From: Amber Willard <Amber.Willard@arun.gov.uk>
Sent: 18 September 2026 09:11
To: Planning.Responses <Planning.Responses@arun.gov.uk>
Subject: FW: WA/89/26/NMA — Objection: cumulative changes to the approved reserved-matters scheme

Subject: WA/89/26/NMA — Objection: cumulative changes to the approved reserved-matters scheme

Following validation of **WA/89/26/NMA** on 17th September, I have reviewed the published documents against the reserved-matters drawings and supporting information.

Plot 7,8,17,18,20,21,25,26,44,45

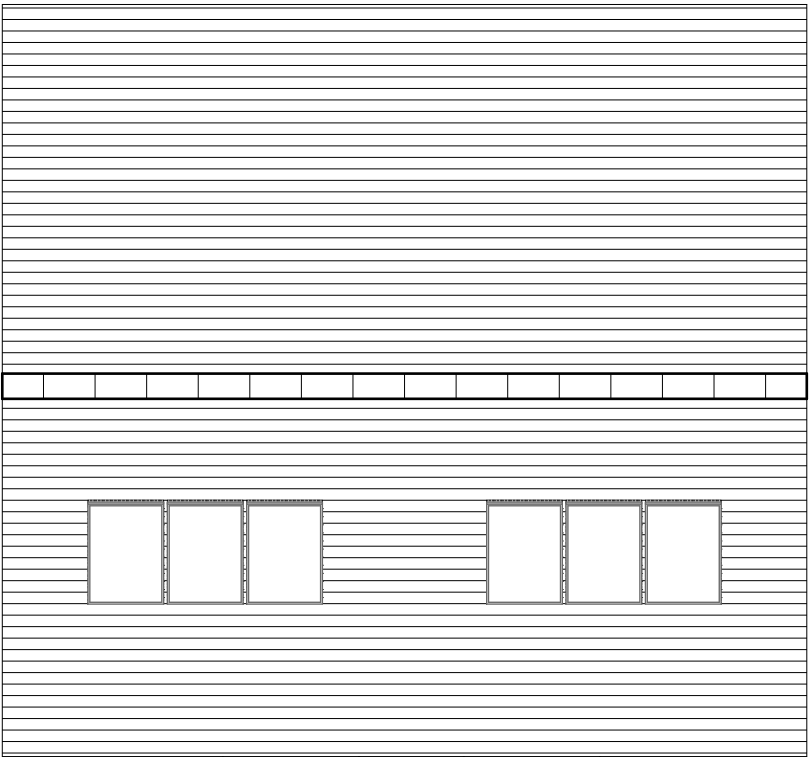
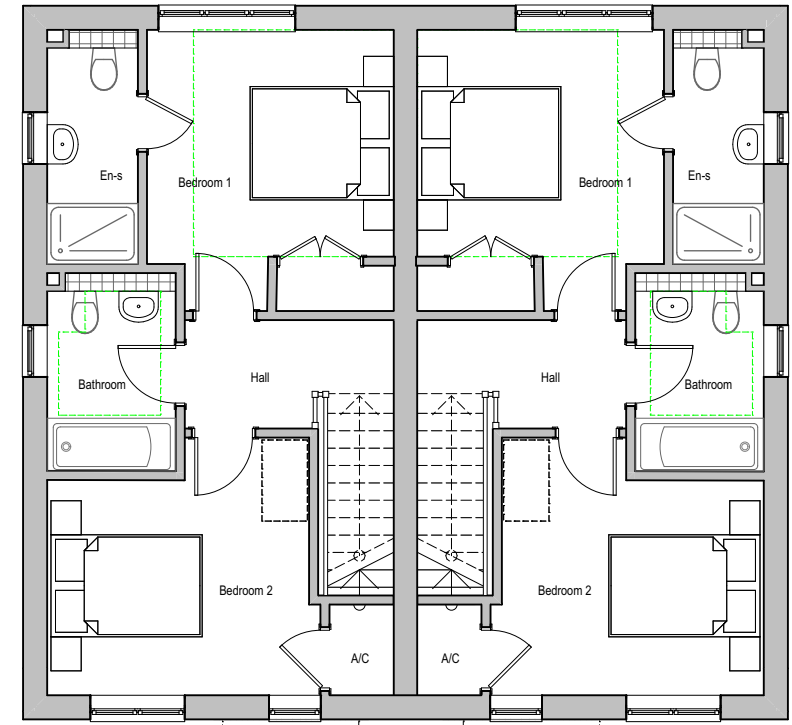
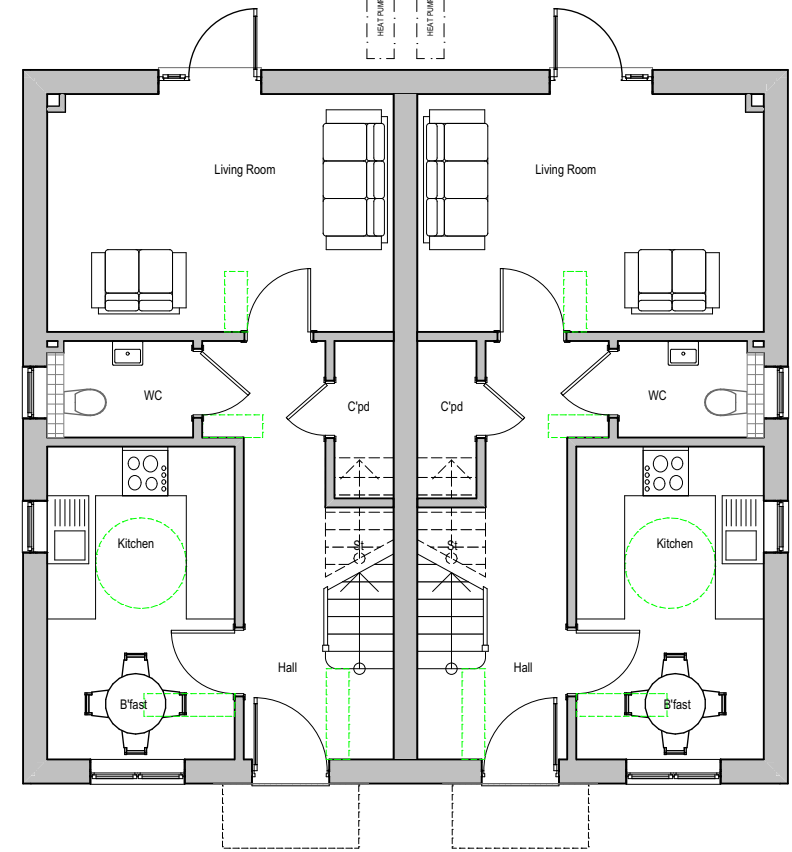
- House-type substitutions at Plots 10 and 11, from HTC to HTB1, and Plots 19 and 43, from HTJ to HTB.
- Replacement of twin-gabled roof forms with a single ridge at Plots 22, 23, 25, 26, 32, 33, 46 and 47.
- Removal of prominent front gables at Plots 31, 42 and 48.
- Removal of bays at Plots 29, 30, 34 and 40.
- Removal of chimneys on identified drawings, including Plots 39, 41, 42 and 48.
- Removal of Plot 28's garage wing, alongside the wider programme of garage omissions.
- Repeated internal replanning, including loss of en-suites and, on identified plots, utility or storage accommodation.

Conversely, Plots 7, 8, 17, 18, 20, 21, 44 and 45 already had the single-ridge HTA form. Their consolidation onto replacement drawings is not itself evidence of roof-form alteration. This distinction reinforces the need for a precise comparison against the governing approved drawings.

PROJECT TITLE
Land West of Yapton Lane
DRAWING TITLE
PLOTS 1-4 Plans_Elevations
DRAWING NUMBER
C9_26_03_PL_HTABA_P3

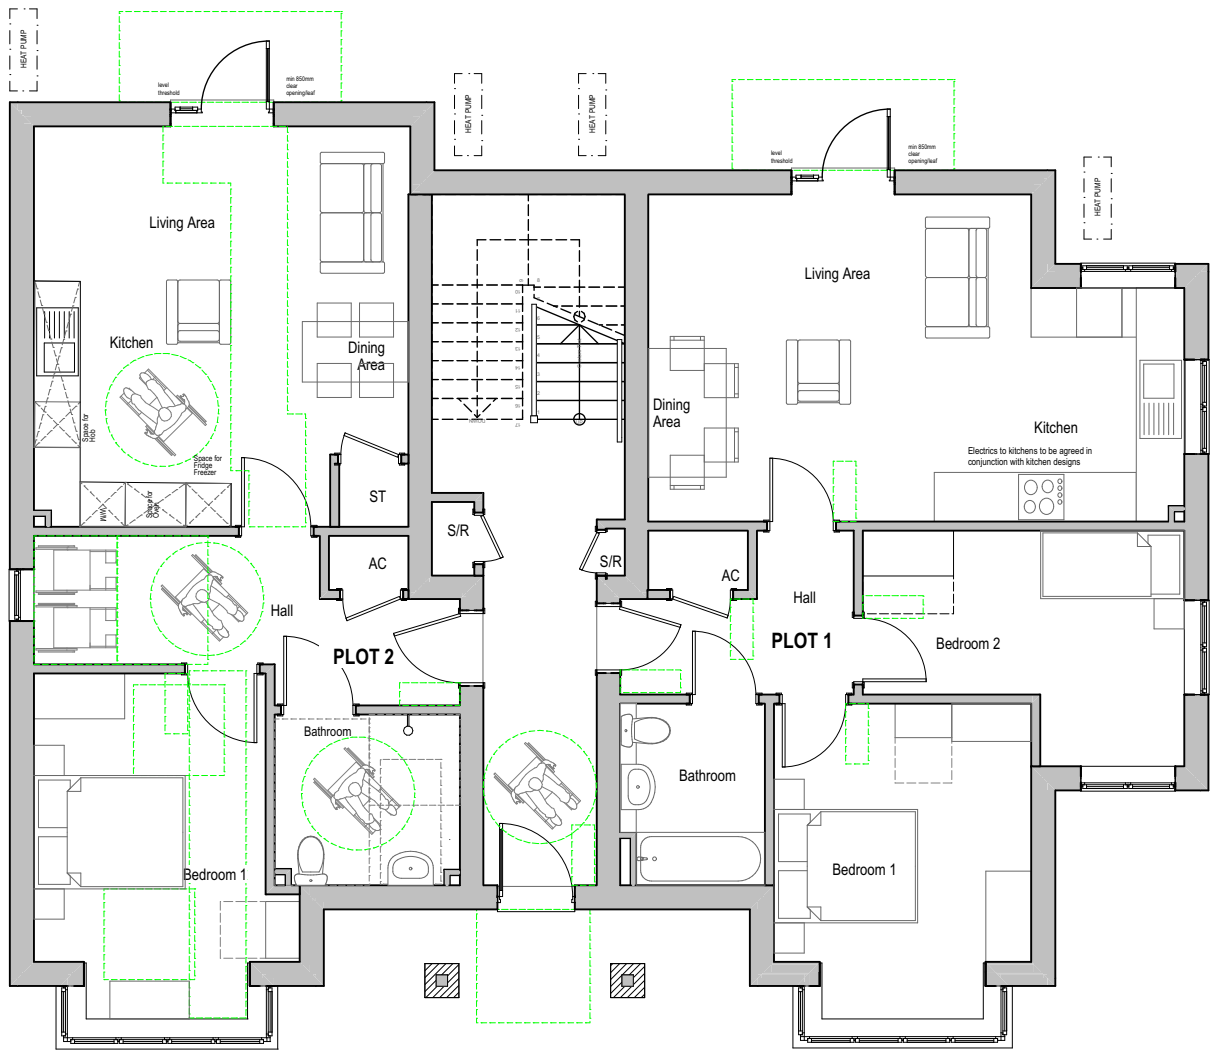
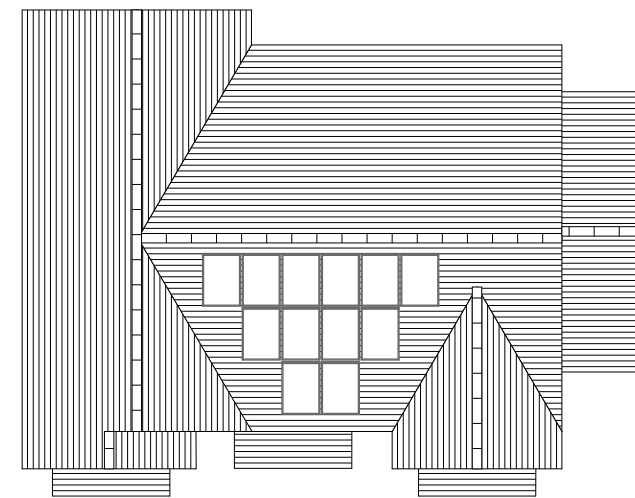
The schedules also appear to change Plots 1 and 13 from 1B2P to 2B3P. Please clarify whether these represent actual accommodation changes or corrections to the earlier schedule.
